Application No: FG/69/22/HH
Site Address: Tanglewood Rifside Gardens Ferring BN12 6QH
Description of works: Erection of single storey front and side/rear extensions and installation of rear roof terrace and cladding to dwelling.

Thank you for your internet representation made on 18th May 2022 which has been recorded as an objection with the comments as follows:

Job Number: AR-162 Drawing Number: 03 Revision: Revision

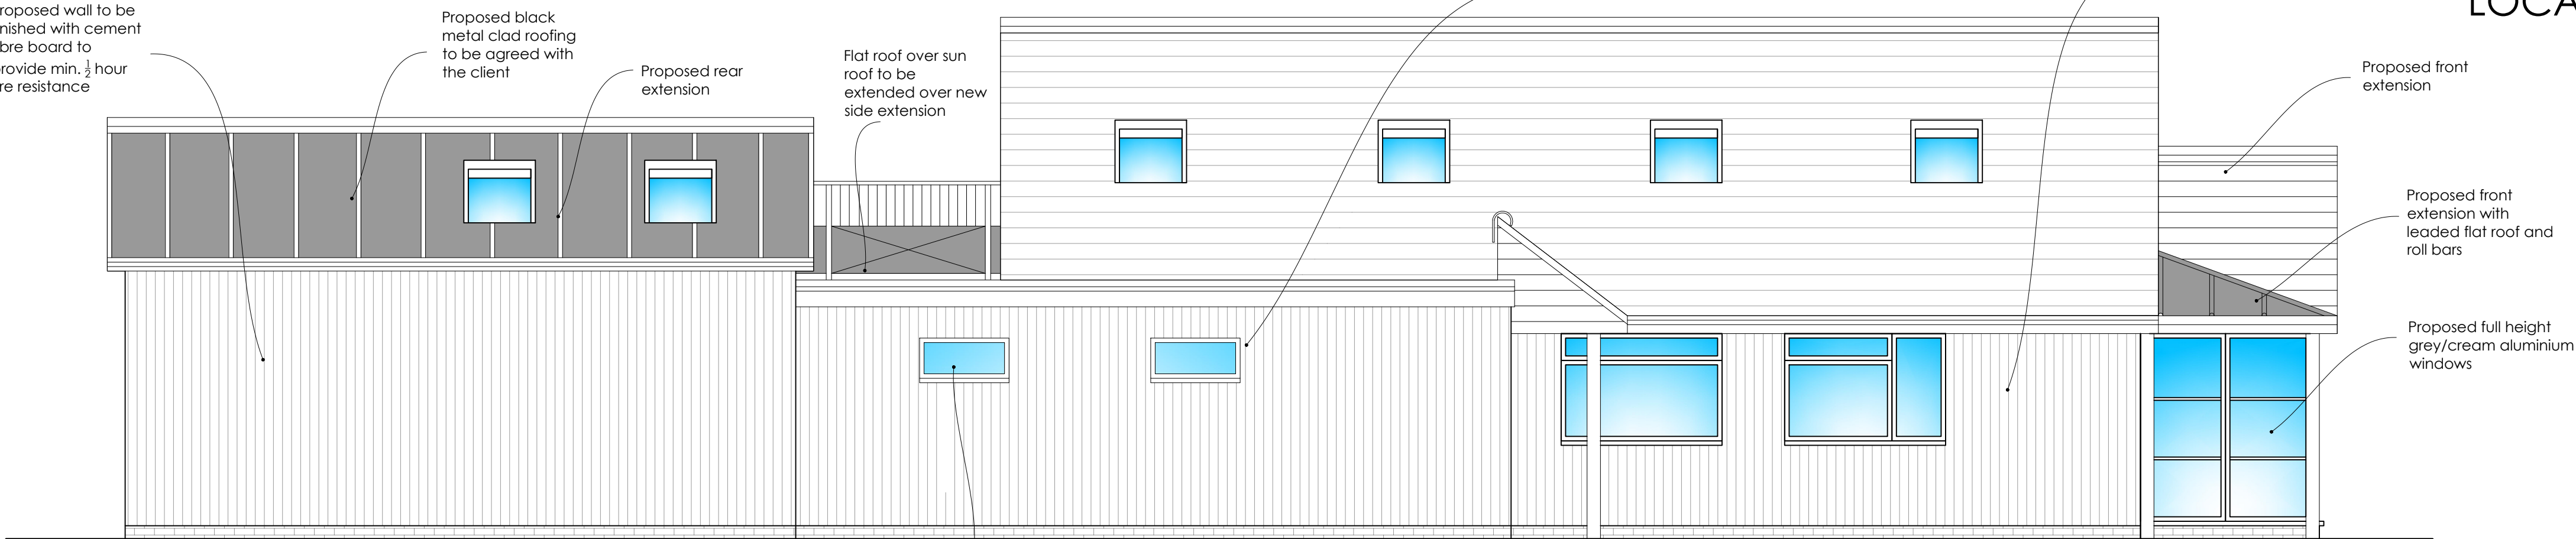
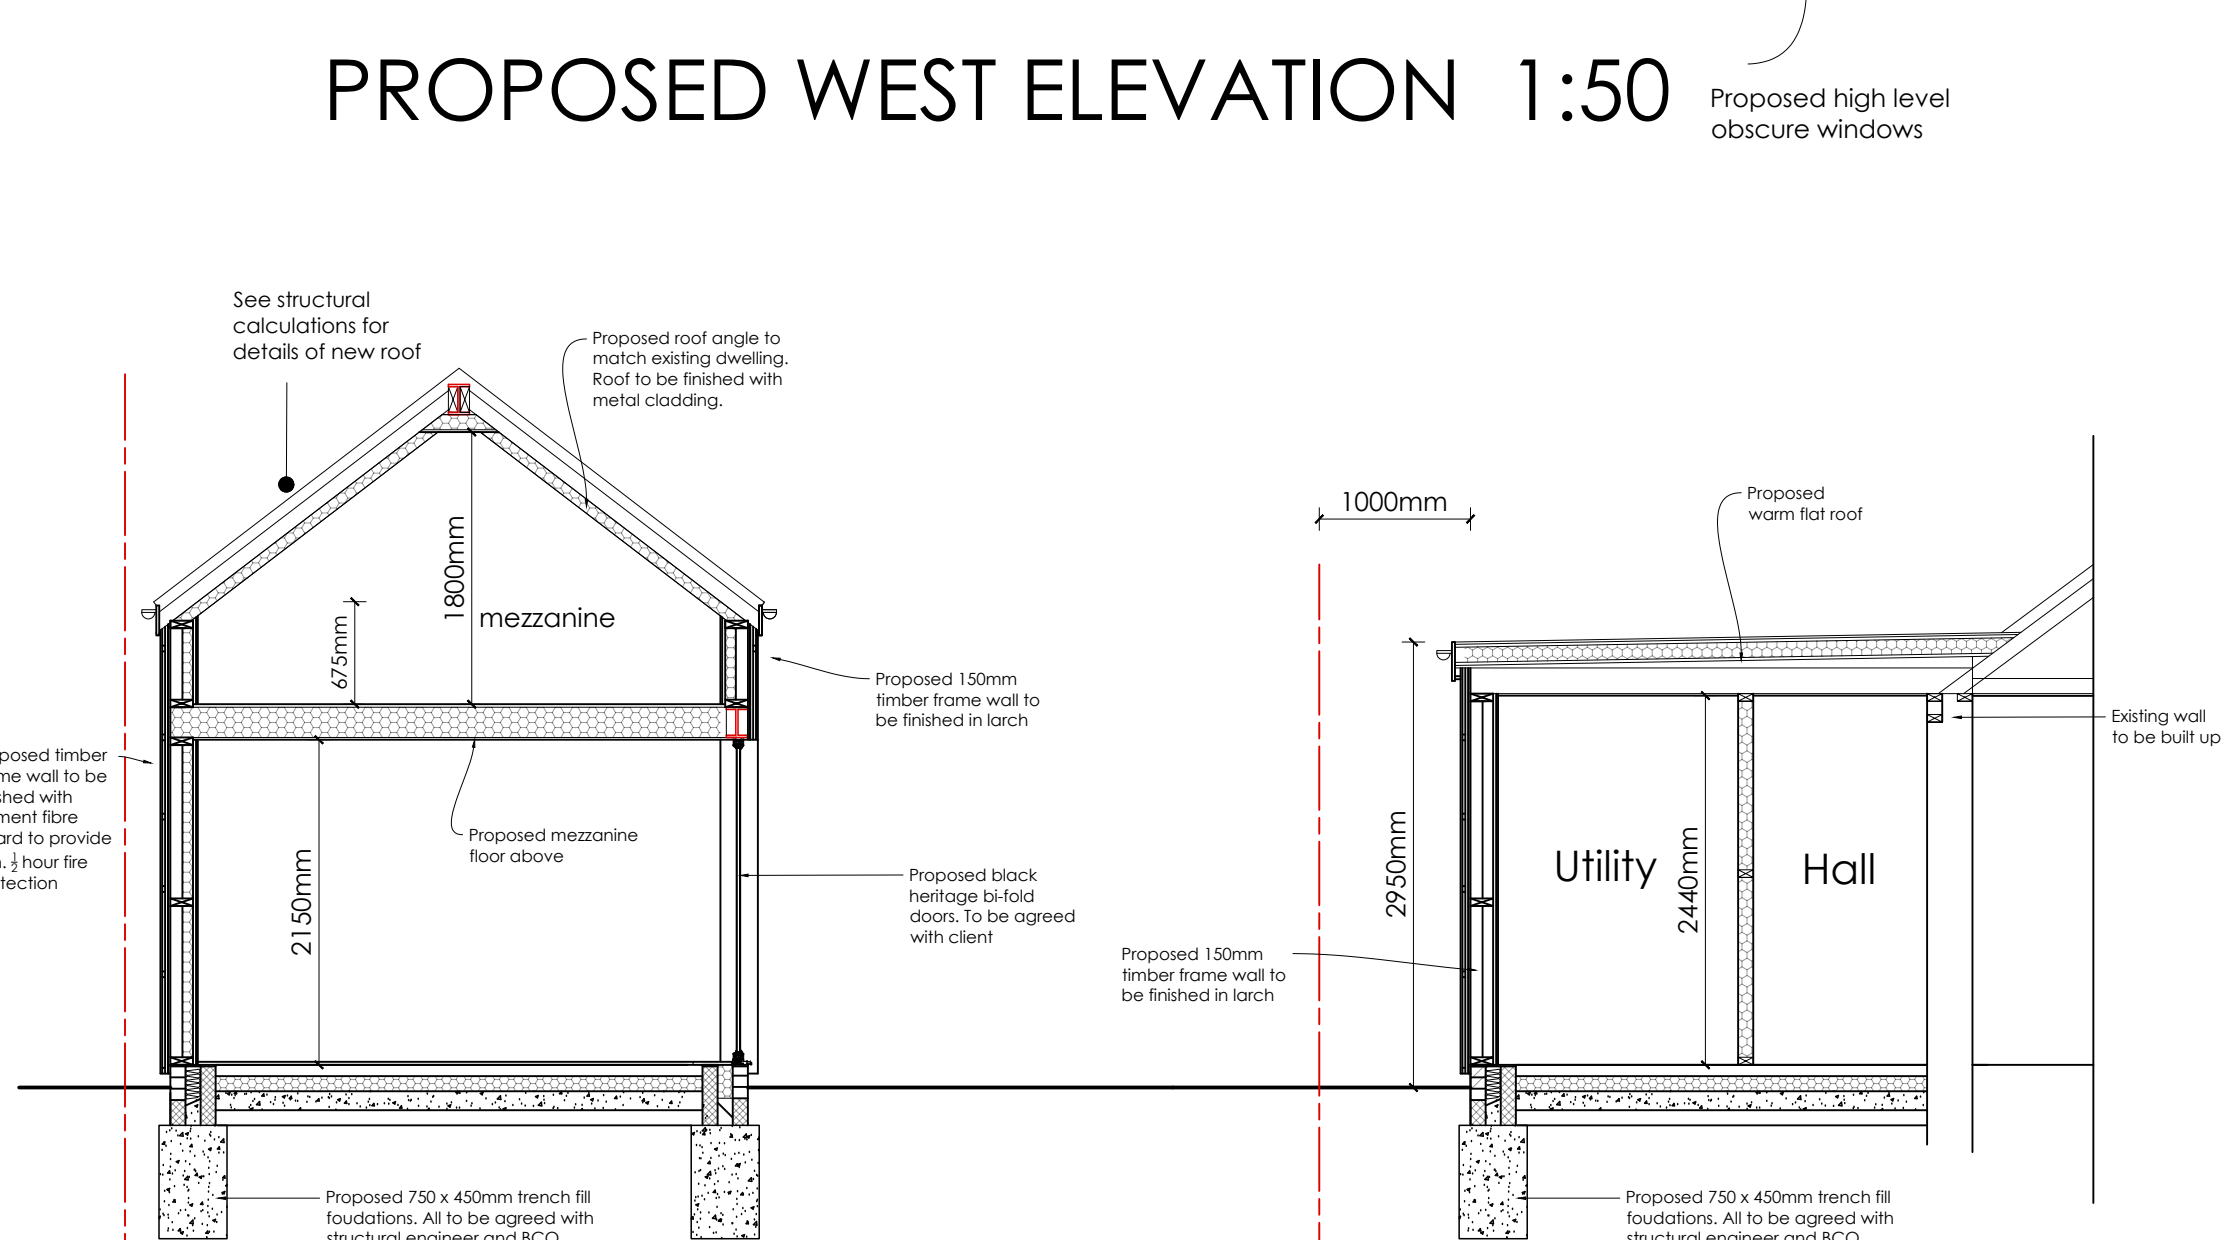
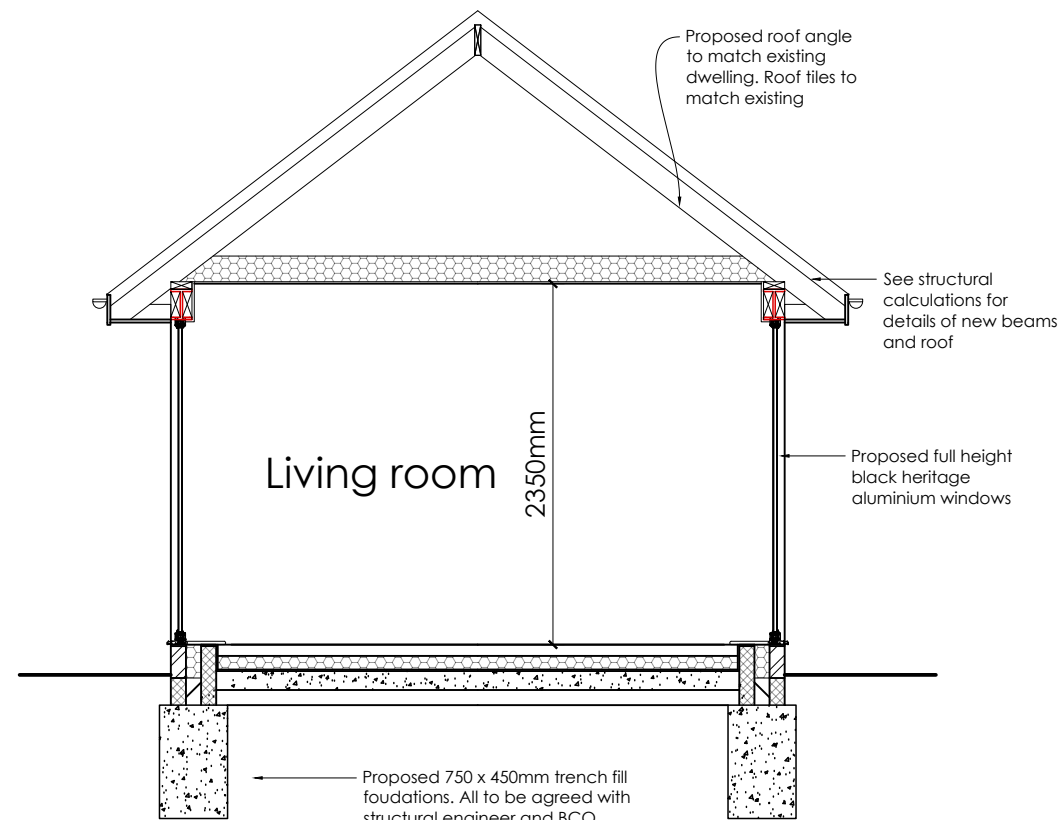
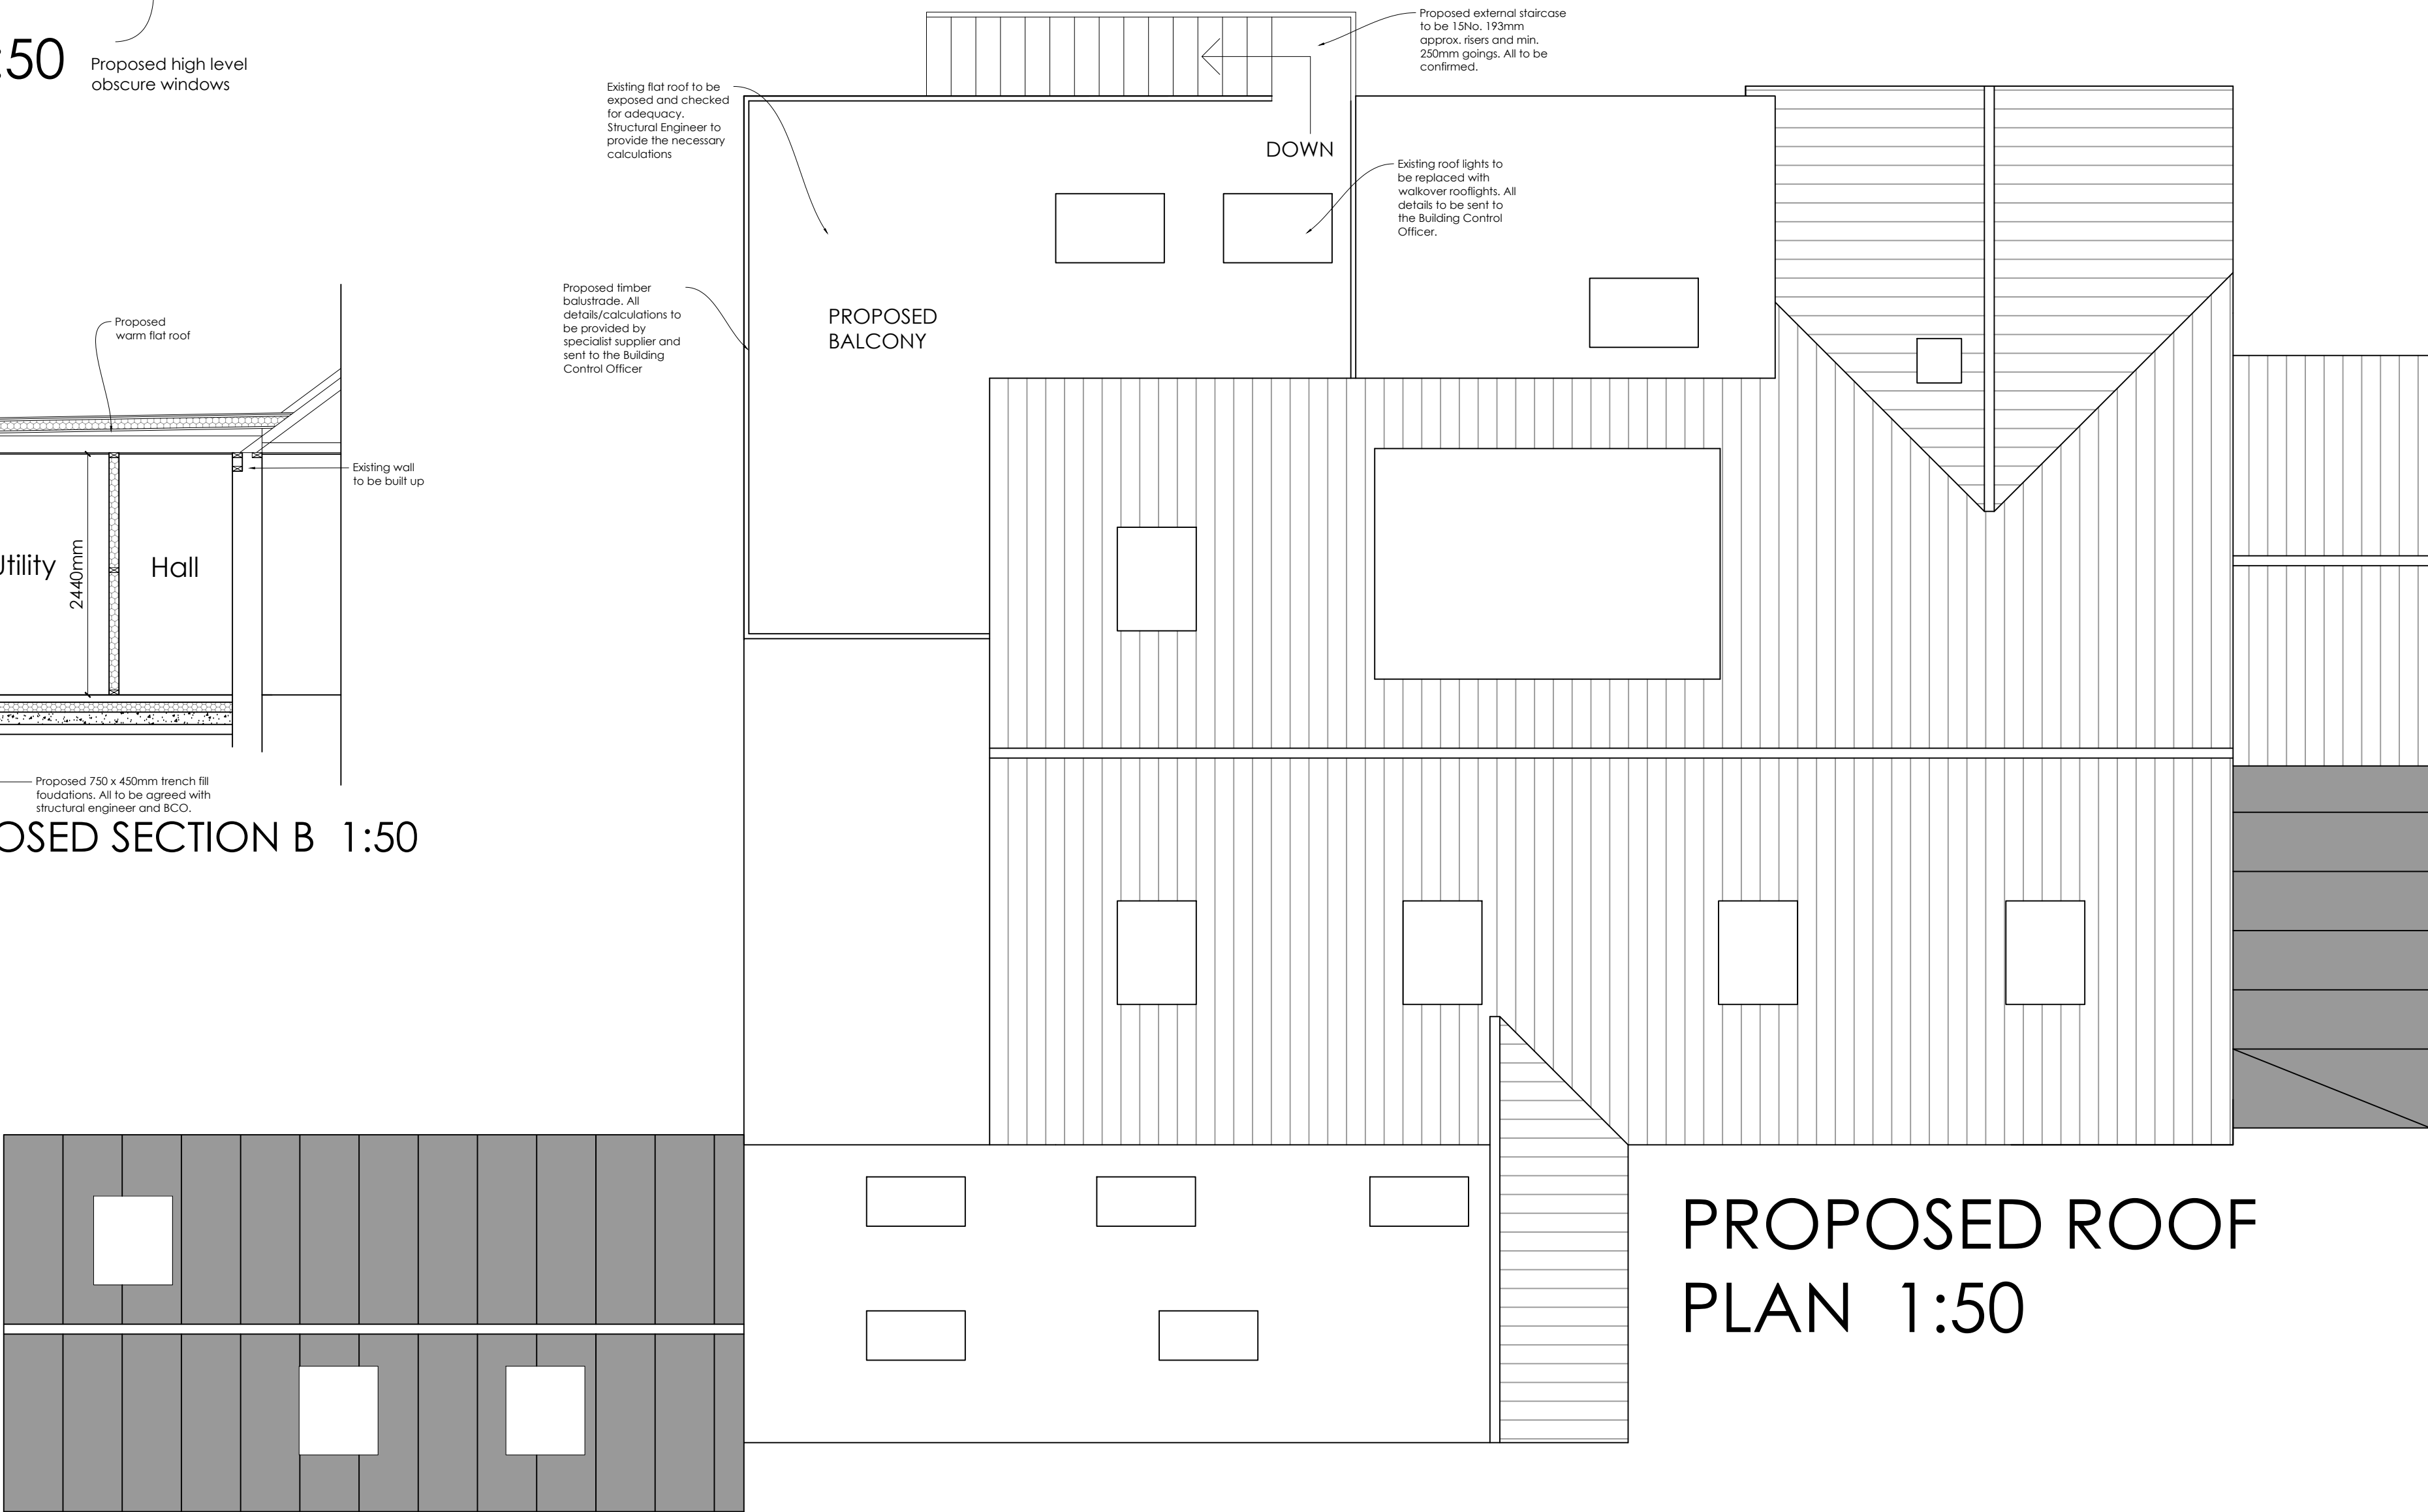
Both the first floor terrace and access stairs would overlook our garden and give views directly into our living room and kitchen and give a part view into our rear bedroom. Our privacy would be severely affected.
